COUNTY OF HARNETT LAND USE APPLICATION

Re: Status of Improvement Permit Application #07-5-17225

Re: Status of Improvement Permit Application #07-5-17225R

Revision 1 1=50'

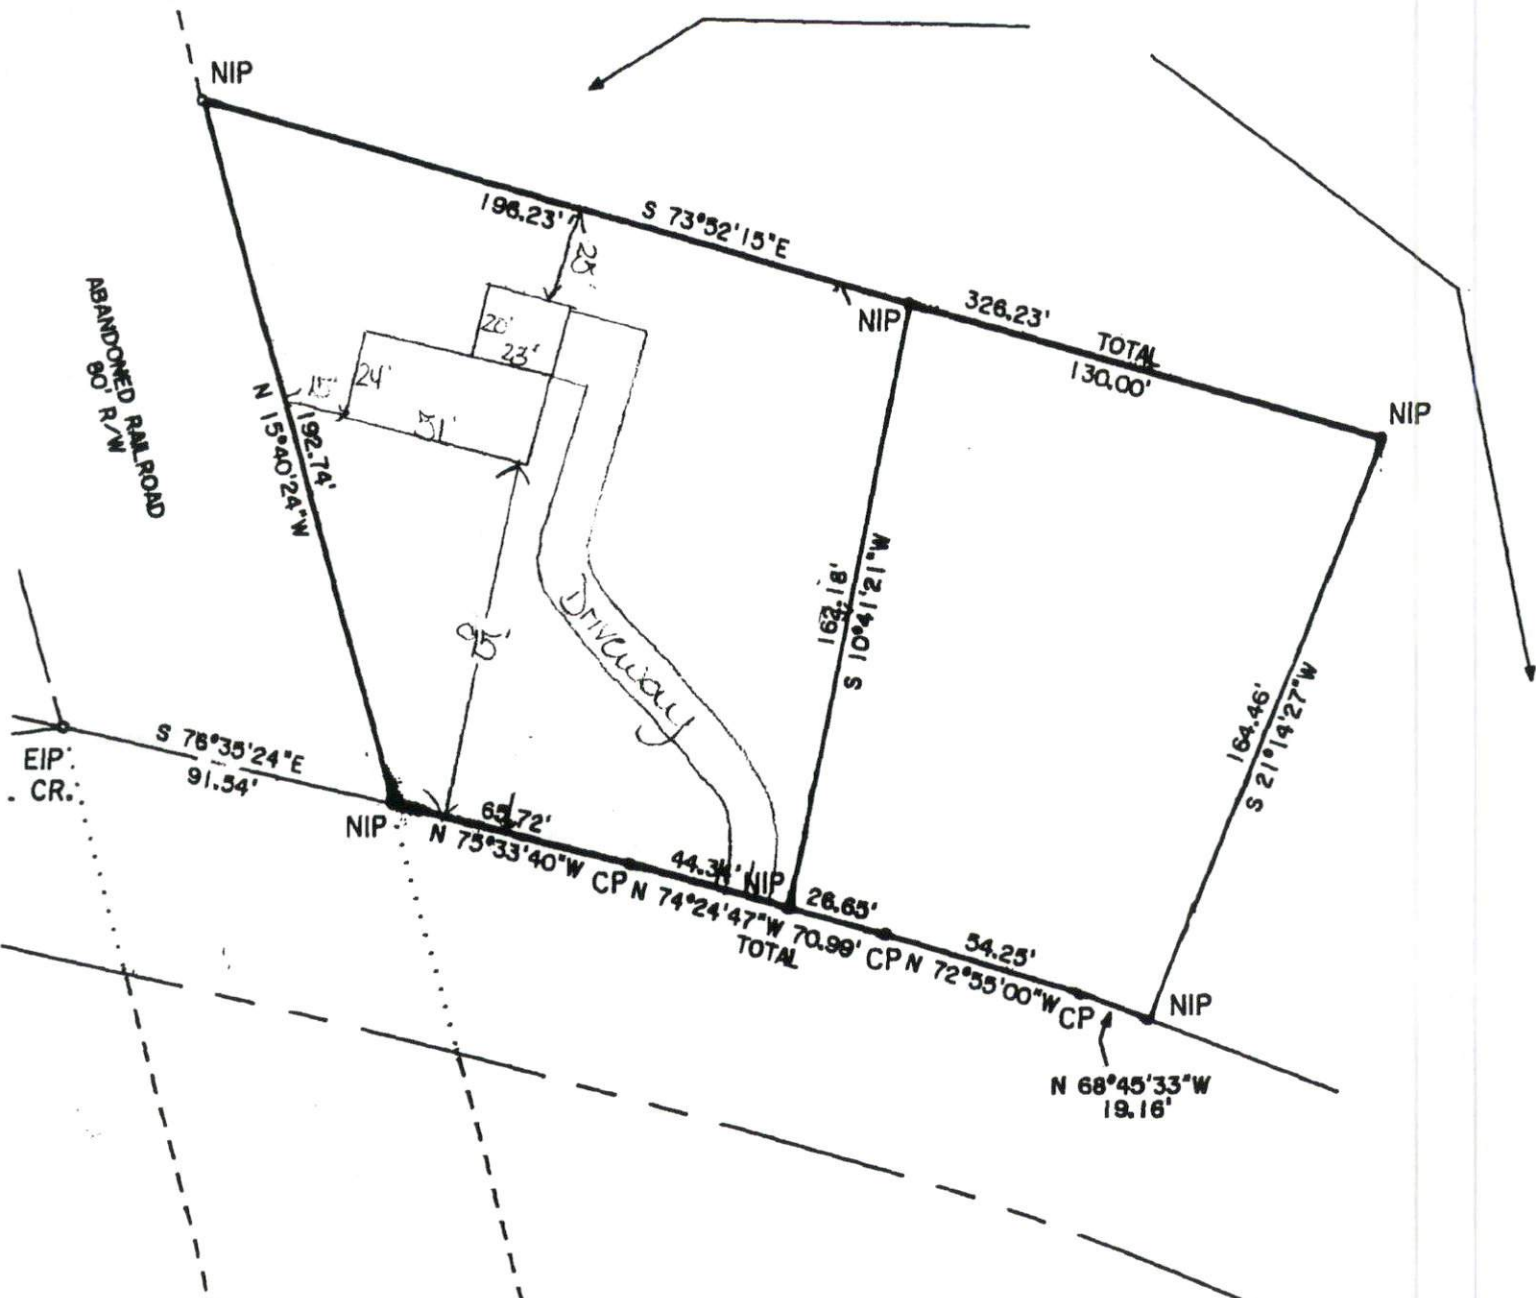
- 1. Property lines/corners not marked or labeled
- 2. House corners not marked or labeled
- 3. Directions not clear to property
- 4. Property needs brush or vegetation removed
- 5. Backhoe pits required
- 6. Other – Must move house, garage and driveway out of area shown for system and repair. Submit new plot plan to Central Permitting and reconfirm.
